**C. Christian Berg, PE**

February 6, 2020

Re: Lot 1 – 2434 Neills Creek Road  
Lillington, NC

At your request, I have reviewed the plans proposed for new construction at this address. These plans were purchased from Frank Betz Associates and are entitled "The Foxcrofte". The architectural plans are dated 8/9/02, and the structural plans are dated 5/12/03. I reviewed the following sheets:

CEILING JOIST FRAMING PLAN  
 1/4" = 1'-0"

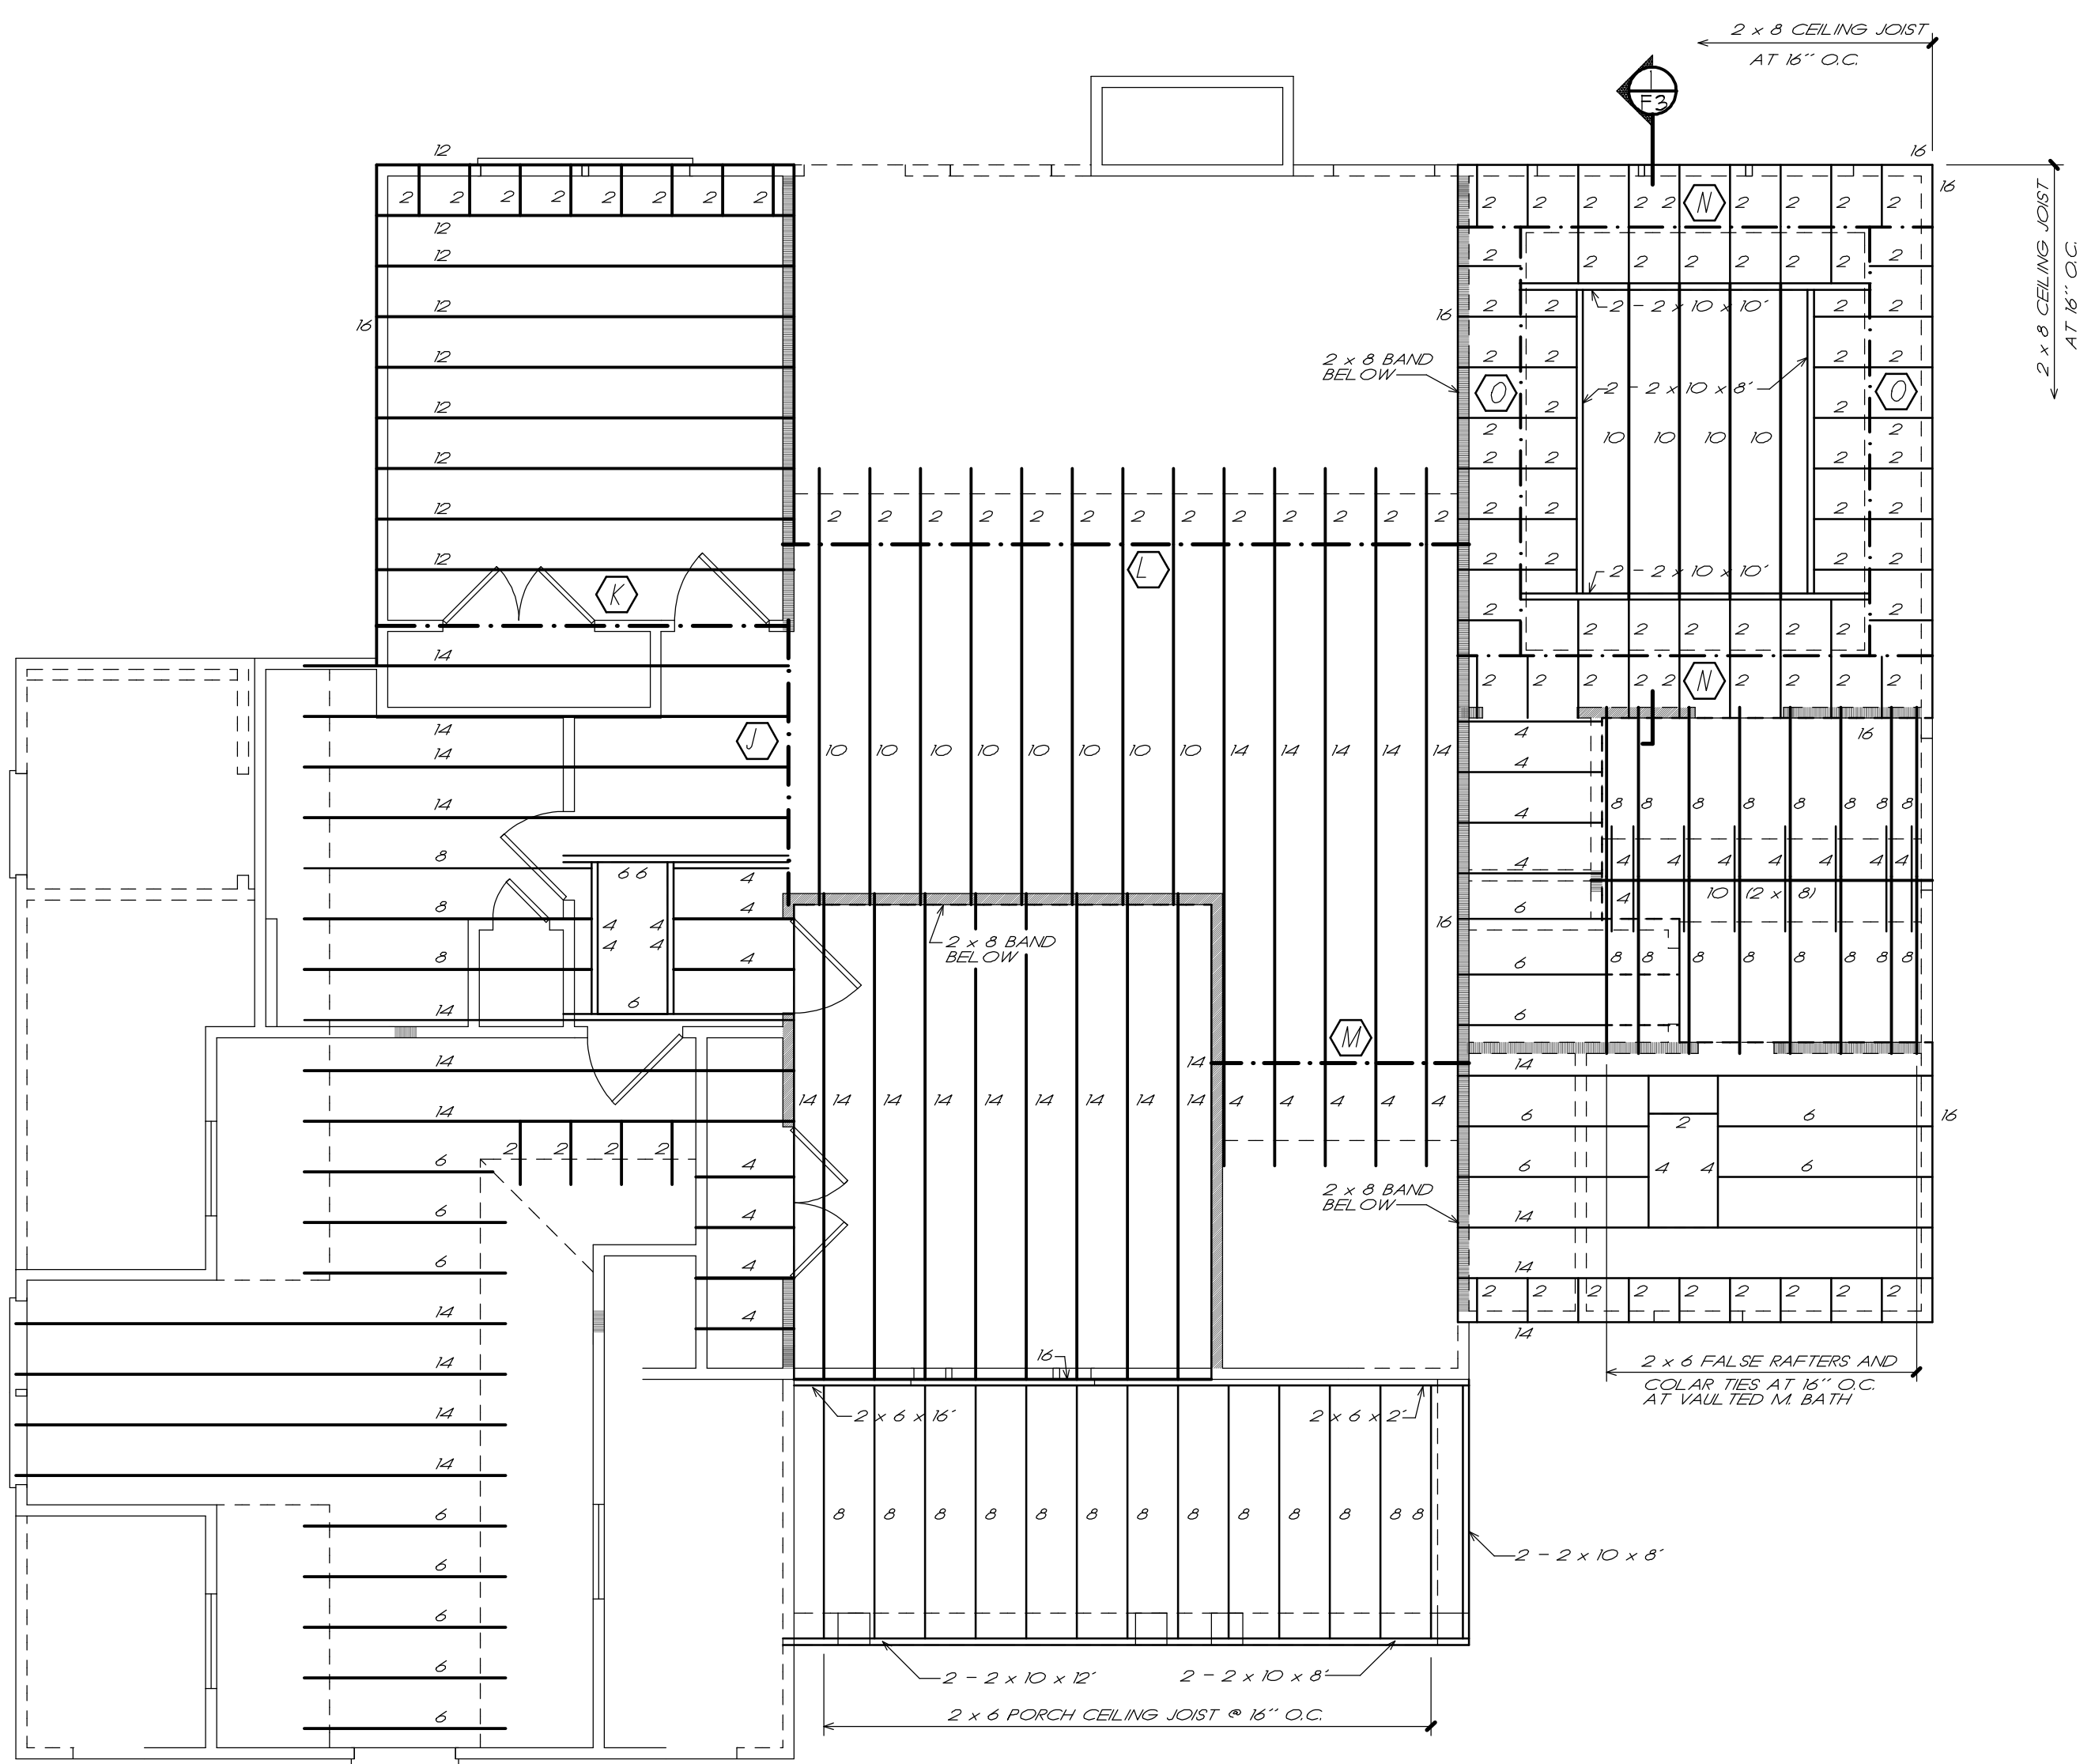
BEAM SCHEDULE	
(N)	2 - 2 x 8 x 8' BEAM FLUSH
(K)	3 - 2 x 10 x 12' BEAM FLUSH ← 3-2x12
(L)	2 - 1 3/4" x 18" x 18' LVL BEAM FLUSH ← 2-1.3/4"x16" LVL
(M)	2 - 2 x 12 x 8' BEAM FLUSH ← 2-1.3/4"x16" LVL
(O)	2 - 2 x 12 x 14' BEAM FLUSH
(P)	2 - 2 x 12 x 12' BEAM FLUSH

**ROOF FRAMING PLAN**  
1/4" = 1'-0"

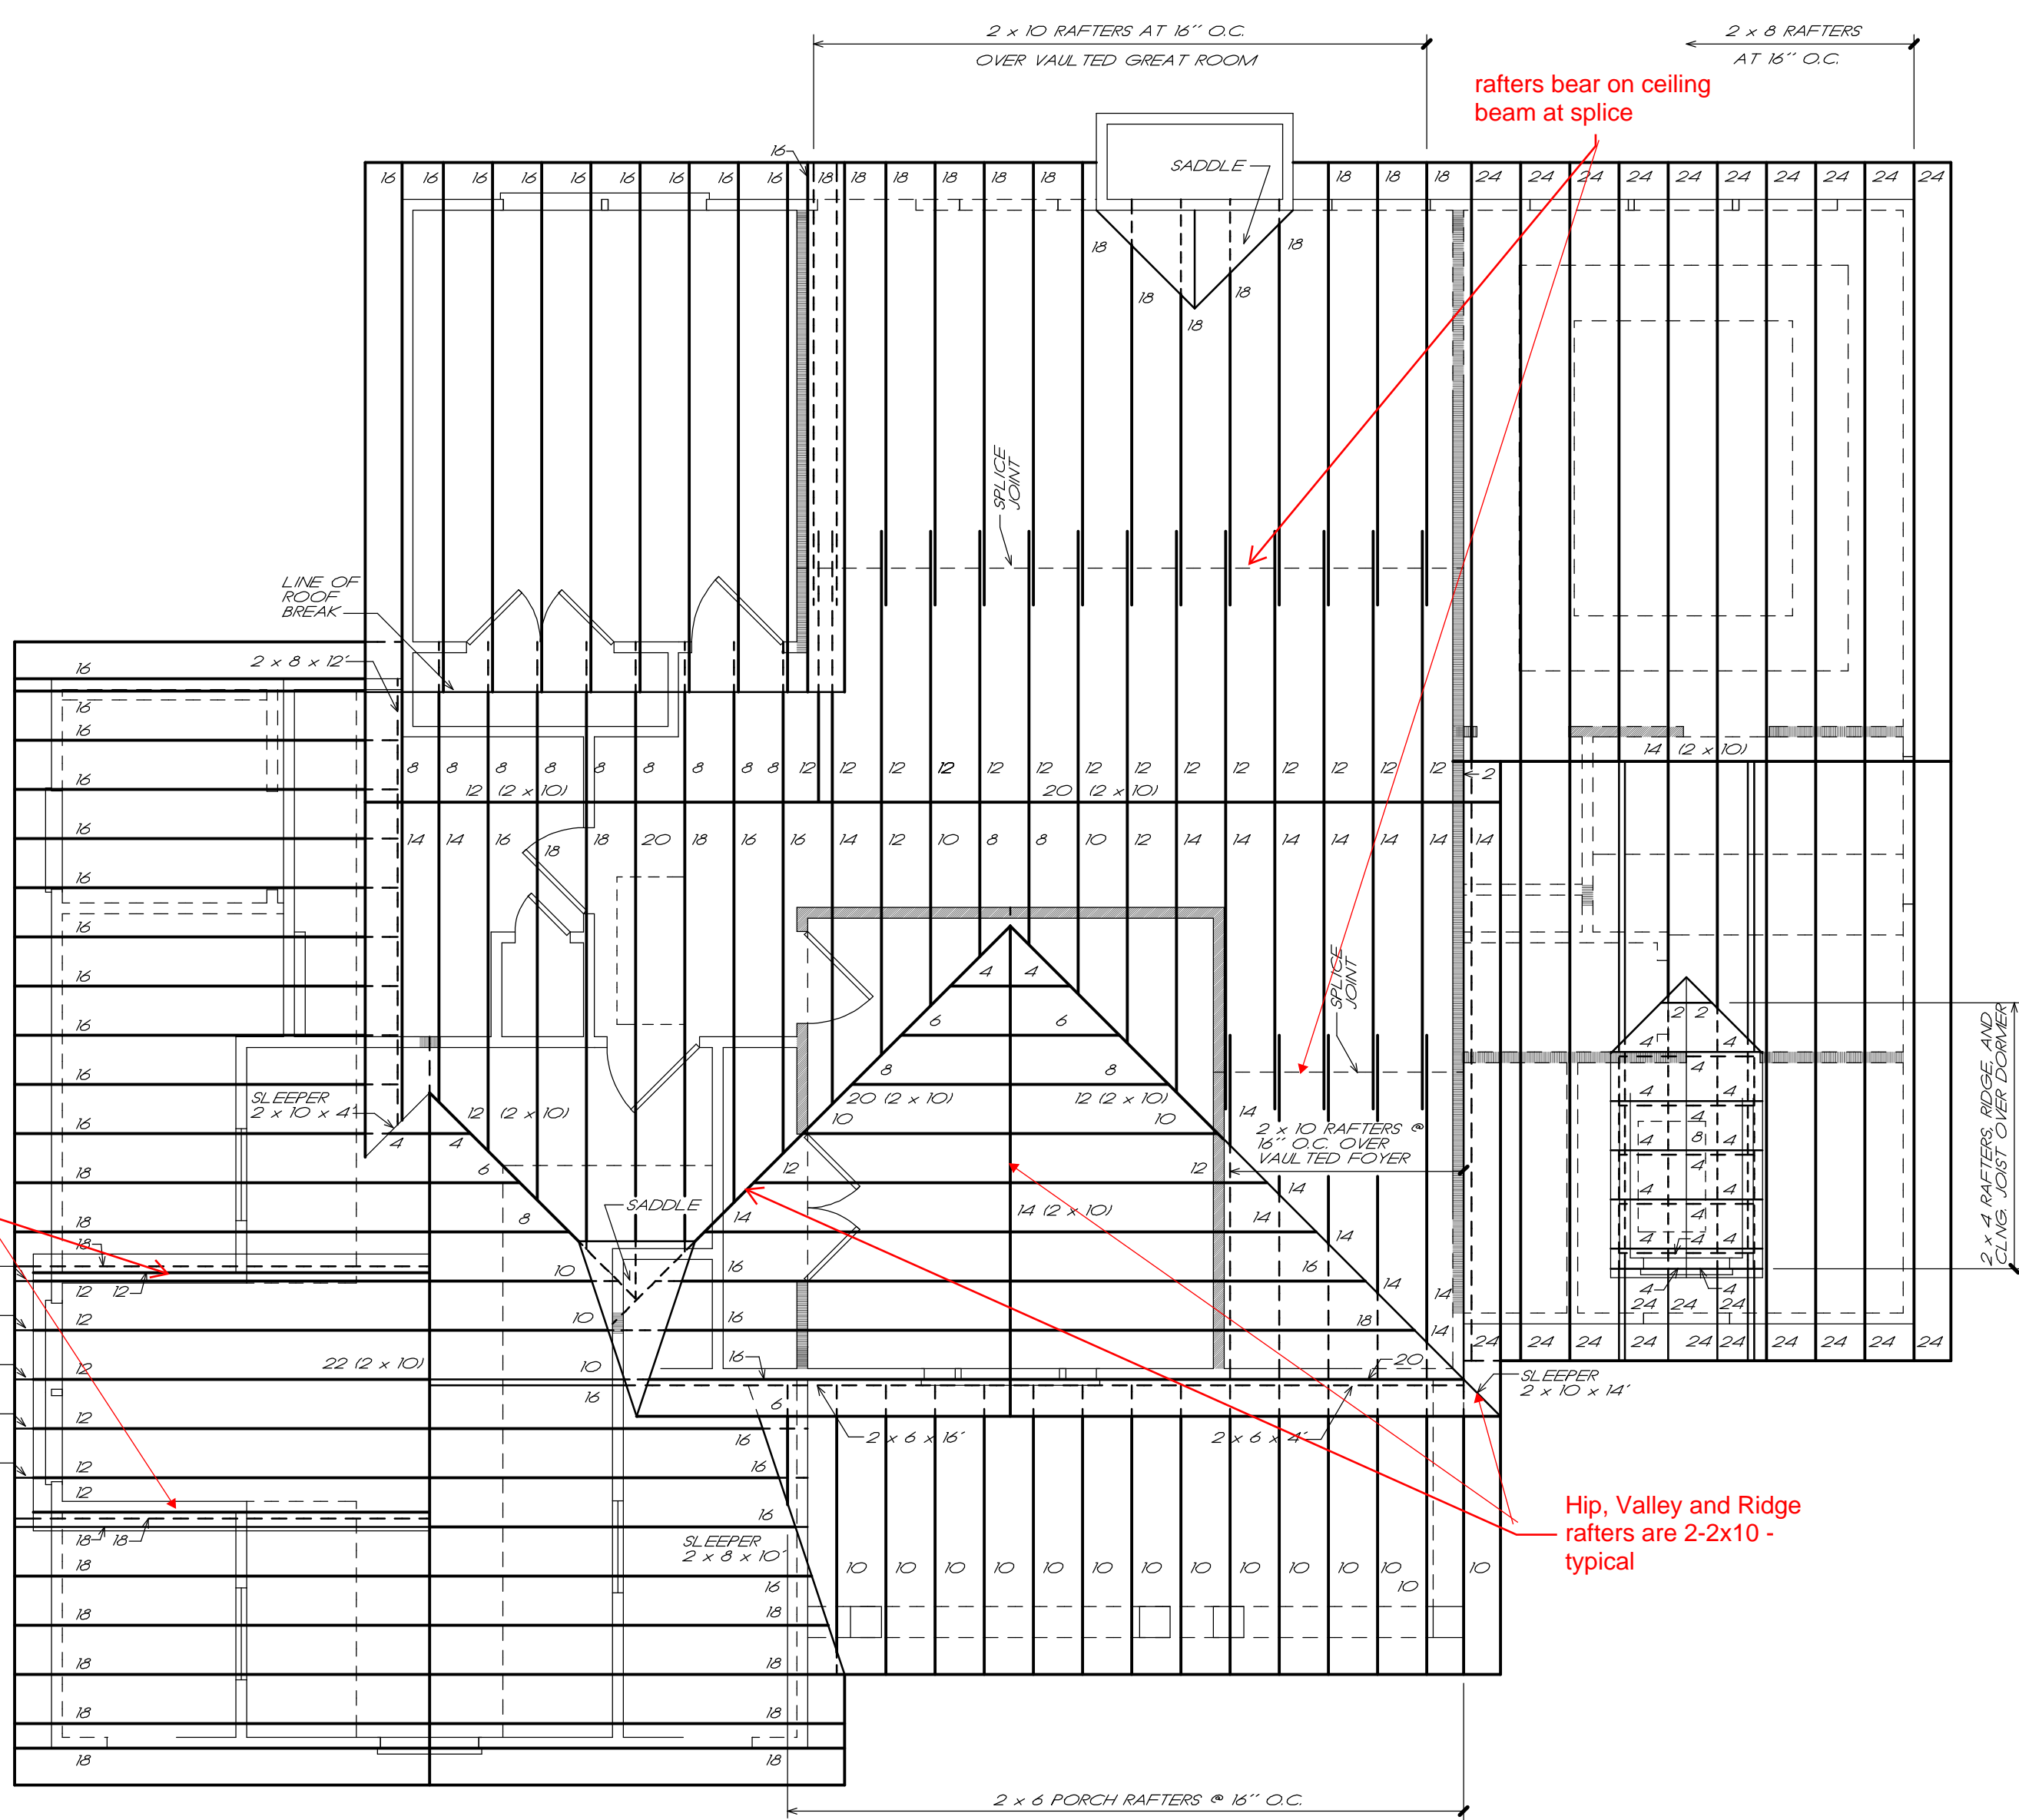
Double joist each side of dormer

Hip, Valley and Ridge rafters are 2-2x10 - typical
